MERIDIAN RANCH: ESTATES AT ROLLING HILLS RANCH NO. 2

PUD DEVELOPMENT, PRELIMINARY PLAN AND FINAL PLAT

LETTER OF INTENT

REVISED OCTOBER 2020

EXHIBIT C

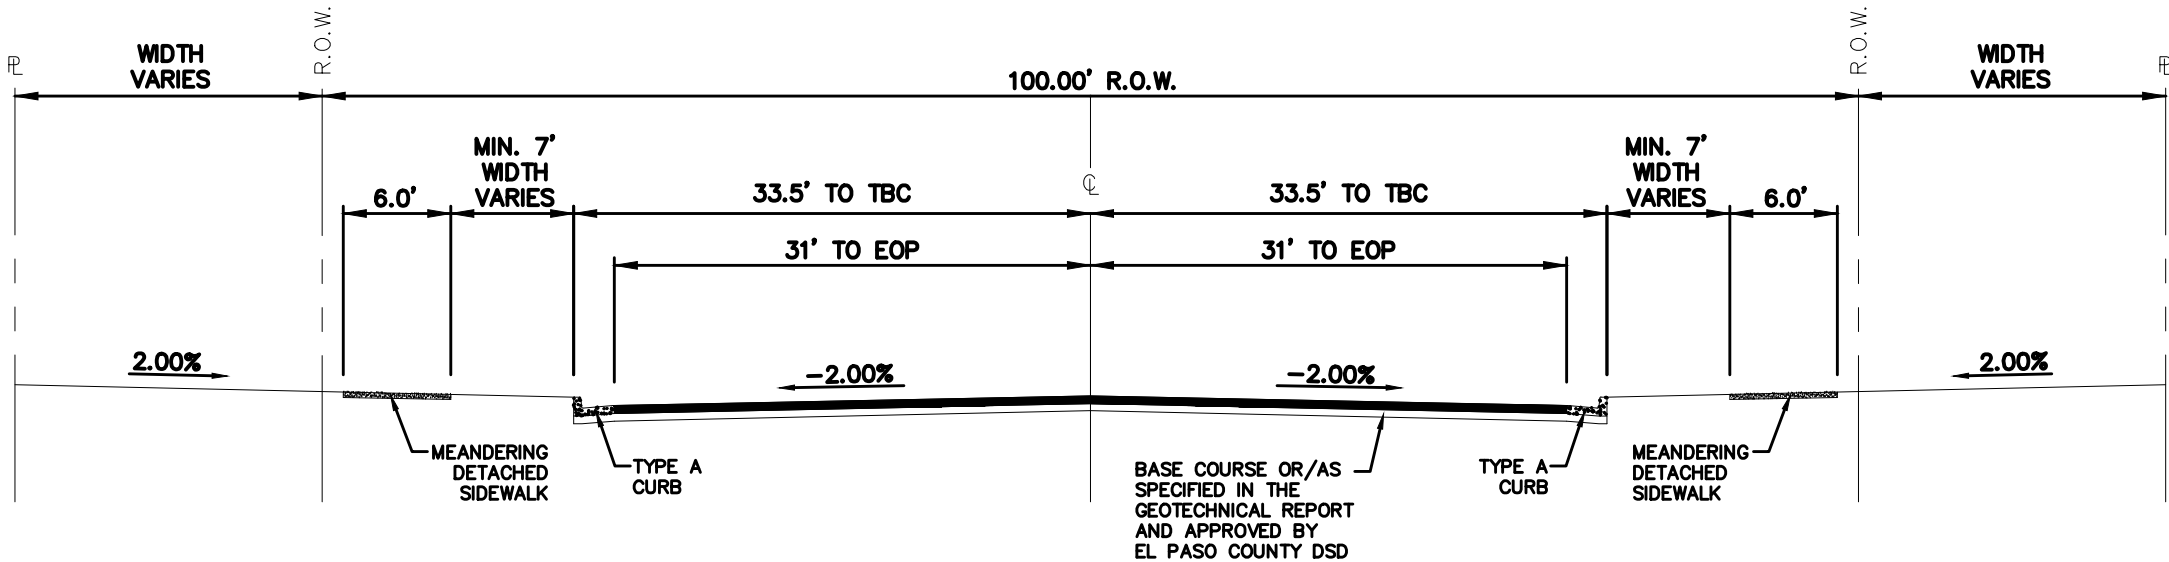
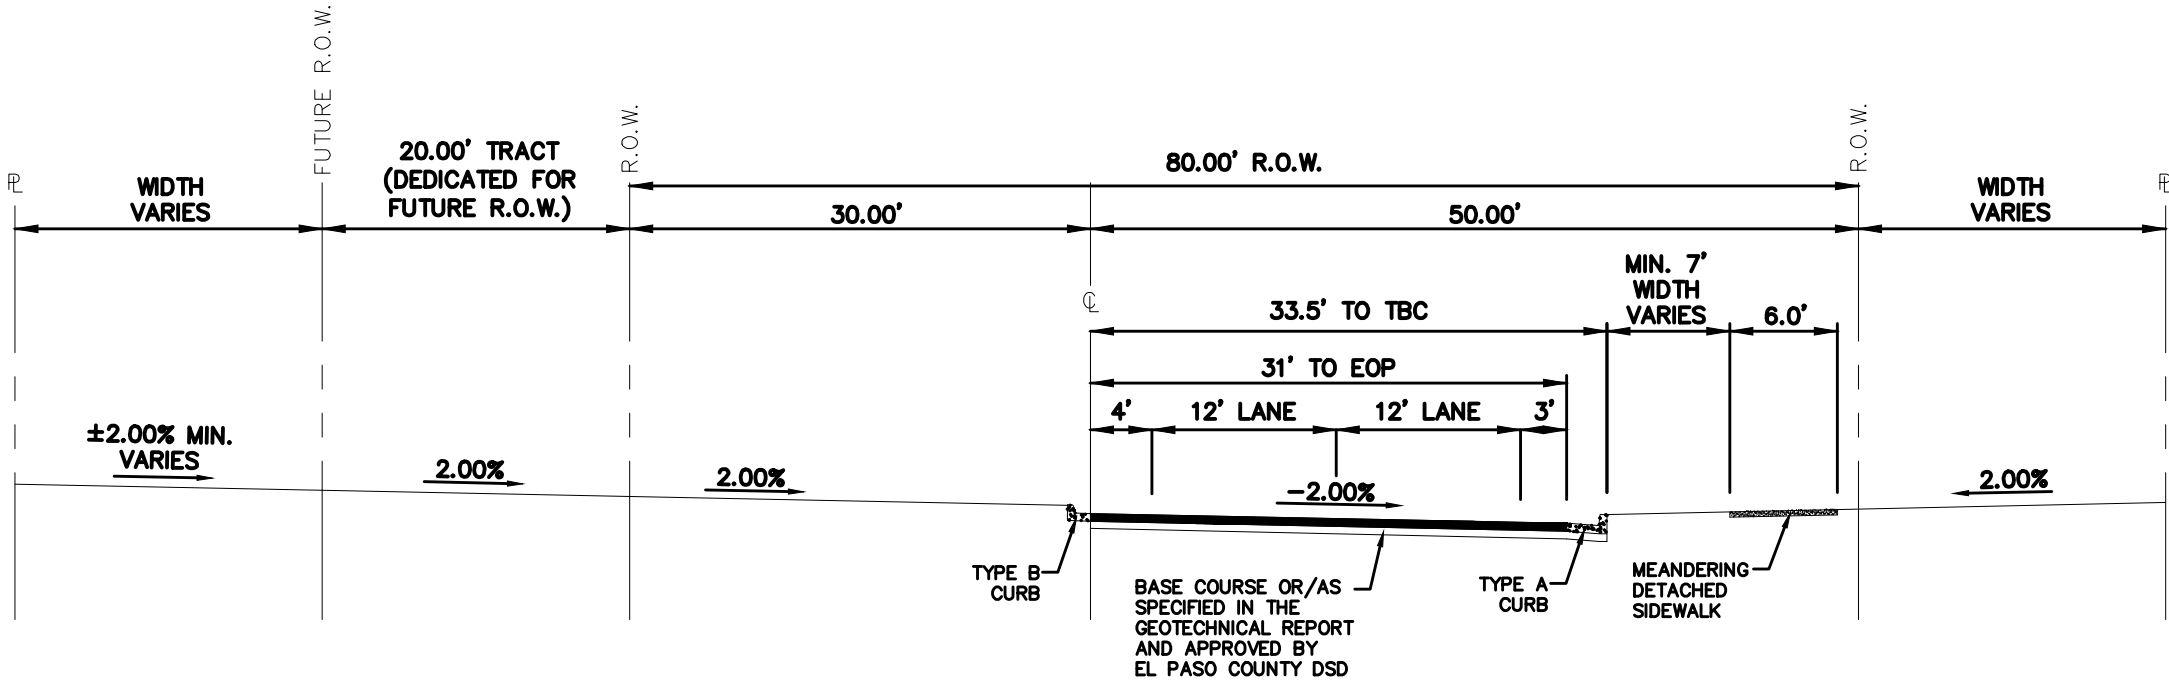
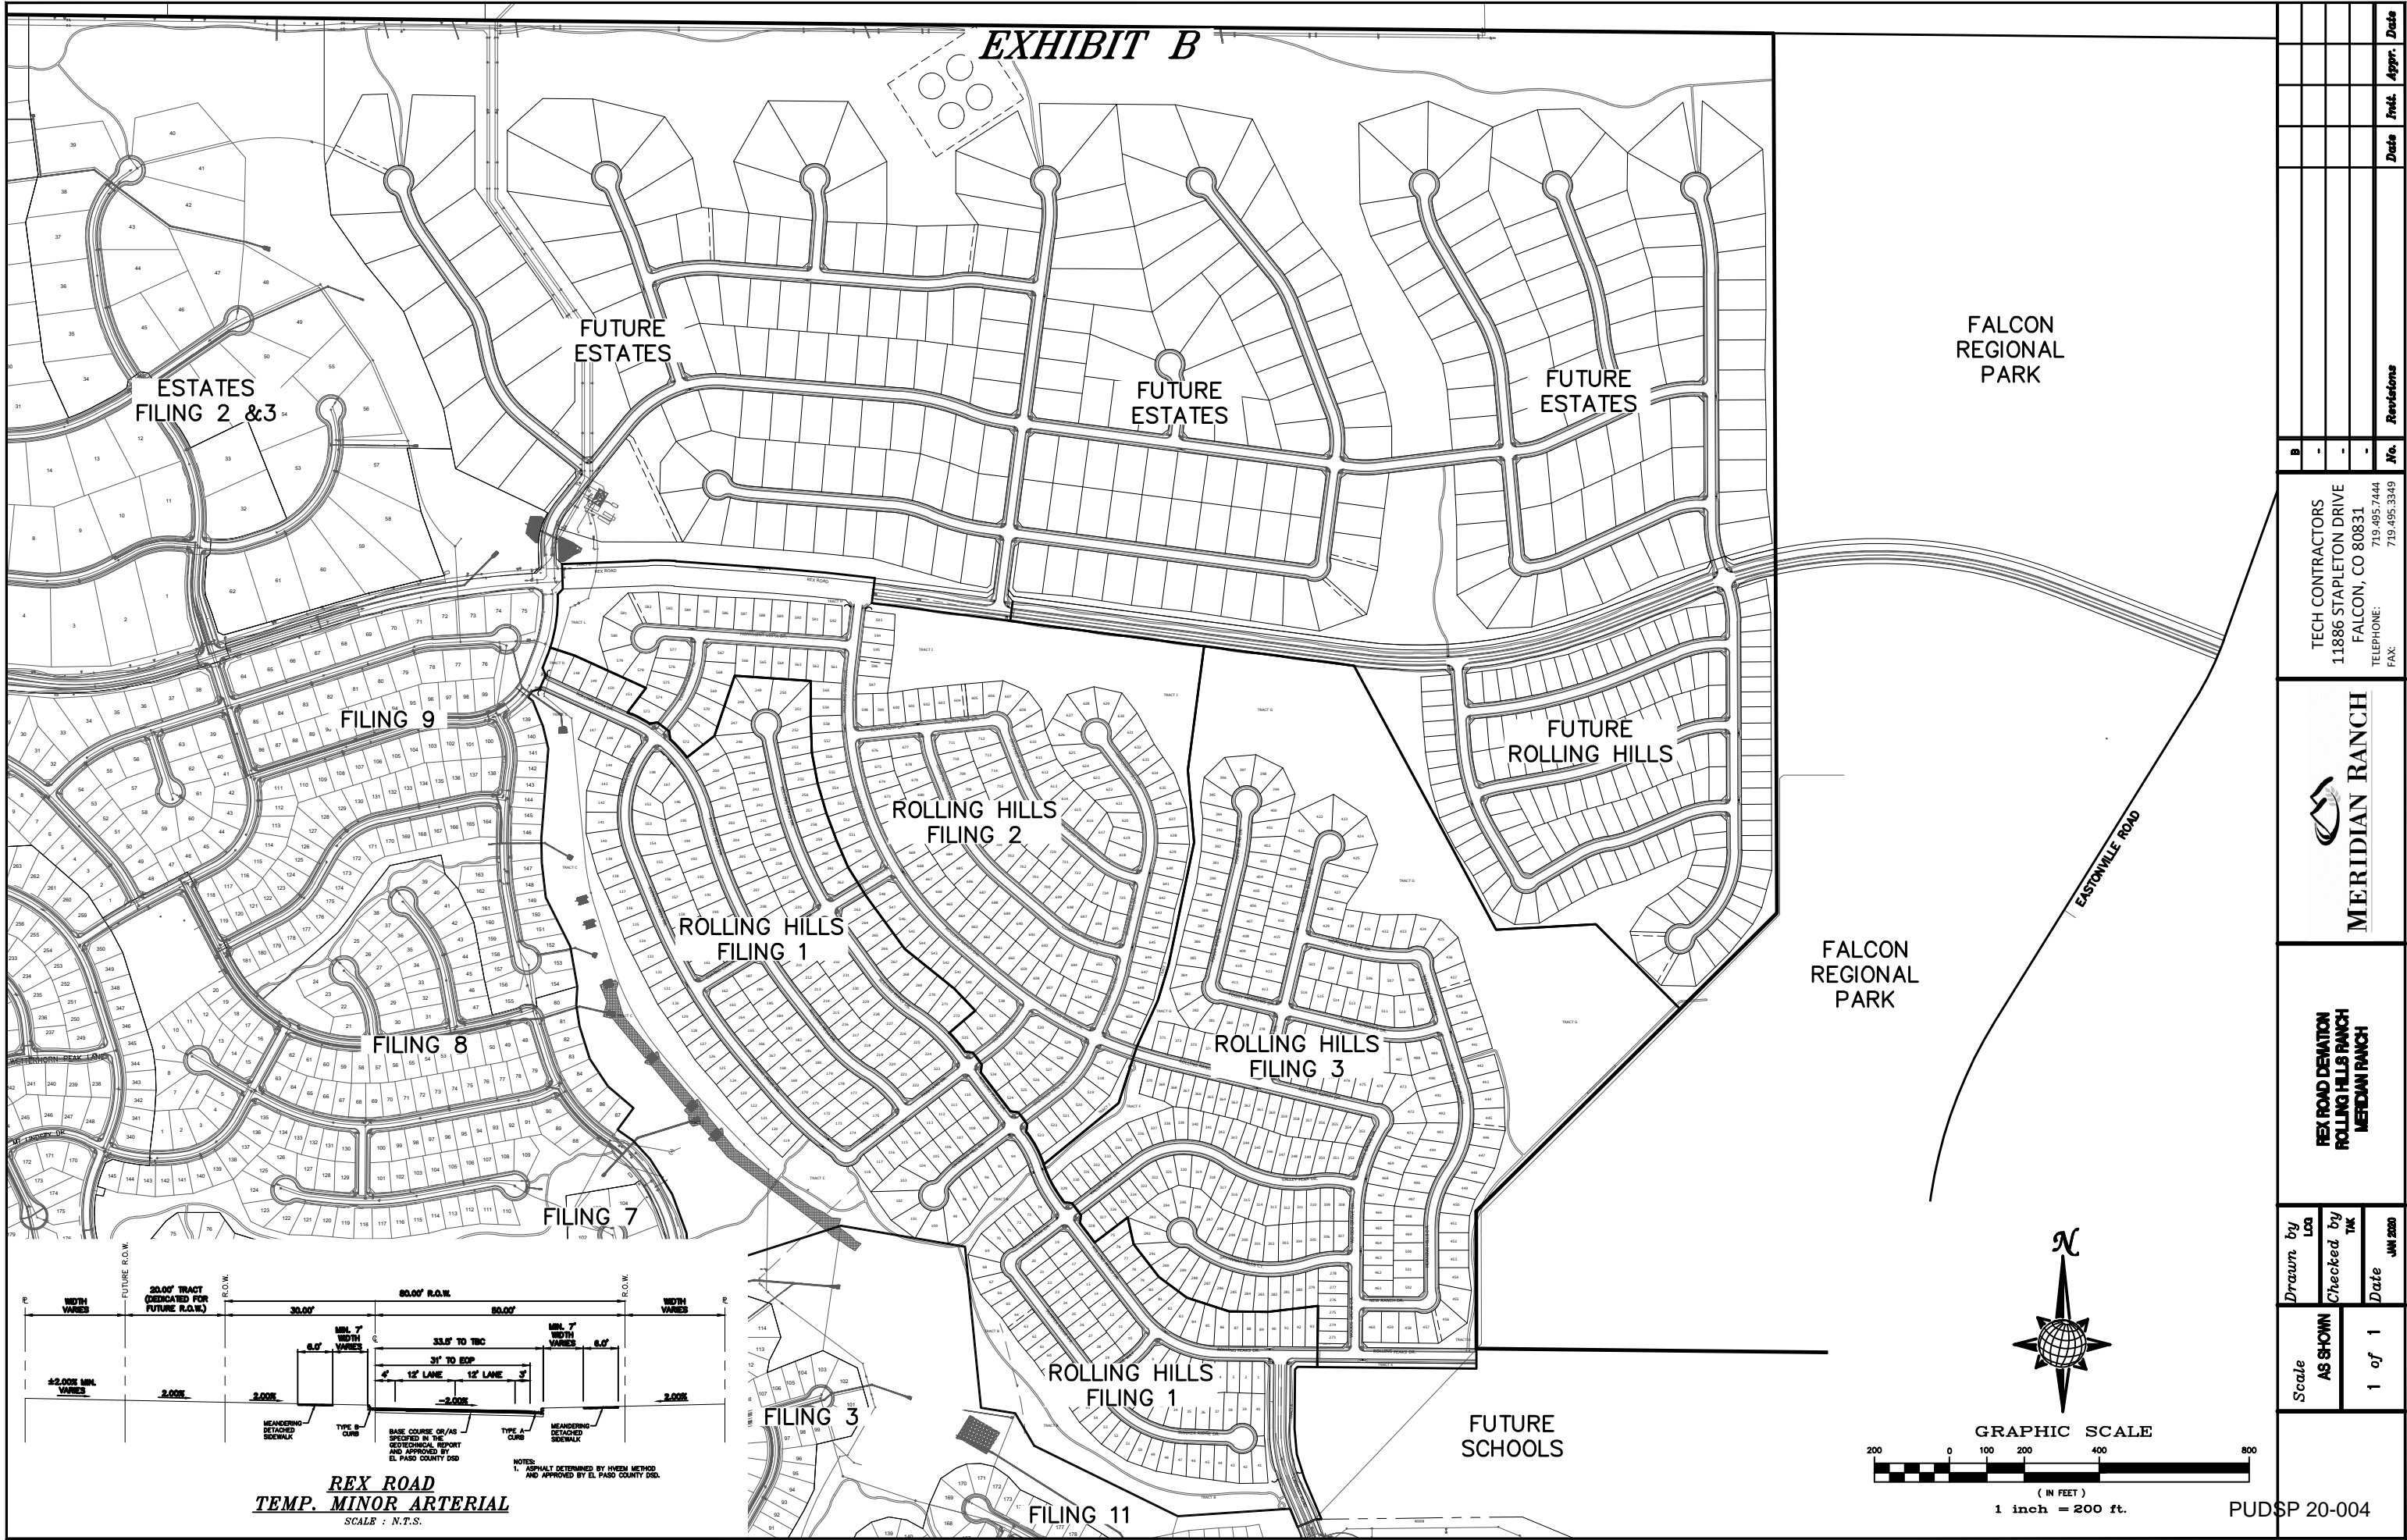
Review 1 comment: The PUDSP for Rolling Hills Ranch Filings 1-3 requested that the section of Rex Road to the east of Sunrise Ridge be constructed as a half section of the Urban Minor Arterial. This request is for it to be a Urban Residential Collector. Appendix A below also has information that this be a half section. Please revise this modification accordingly.
Review 2: Please revise this section to match what was approved with PUDSP199. Please see excerpt from below from the letter of intent of PUDSP199.

intersection of Rex Rd and Estate Ridge Dr .	sac does not create undue safety issues.
					Local and Local Low Volume streets allow for street parking of vehicles.
				Type 3 mailboxes and the pullout for the mailbox shall be located within the right of-way dedication but outside the roadway clear zone.	The request for a deviation is to allow vehicles to park within the clear zone when accessing the Type 3 Mailbox locations.
					This standard requires additional unnecessary street width, curb and gutter and sidewalk be installed that will then need to be maintained by the County.
					The regulation is unreasonable where street parking is allowed, requiring residents to temporarily park outside the clear zone when on-street parking within the clear zone is allowed on the same street section.
				The specific ECM standard a deviation is requested is the criteria to construct Rex Road east of Sunrise Ridge Dr as an Urban 4-lane Minor Arterial based on the 2016 MTCP Map I4: 2040 Roadway Plan classification	To construct Rex Road per the Residential Urban Collector standards.

The previously recorded final plats, located west of this project create a corridor of only 60' wide. This restriction provides sufficient room for an Urban Residential Collector and restricts the ability to construct the Urban Minor Arterial in this section west of the proposed project.
or 3.2 by on,	Construct Rex Road east of Sunrise Ridge Dr as an Urban 4-lane Minor Arterial based on the 2016 MTCP Map I4: 2040 Roadway Plan classification	ECM Section 2.2.4.B.3 & 2.3.2	Design Standards by Functional Classification	The alternative design is to construct Rex Road east of Sunrise Ridge Drive as a half section of the Urban Minor Arterial. Transition from a Residential Urban Collector to the half section east of Sunrise Ridge Dr continuing east to proposed Rolling Ranch Drive.	The prev Estates a Meridian this proje wide. This room for and restri Urban Min
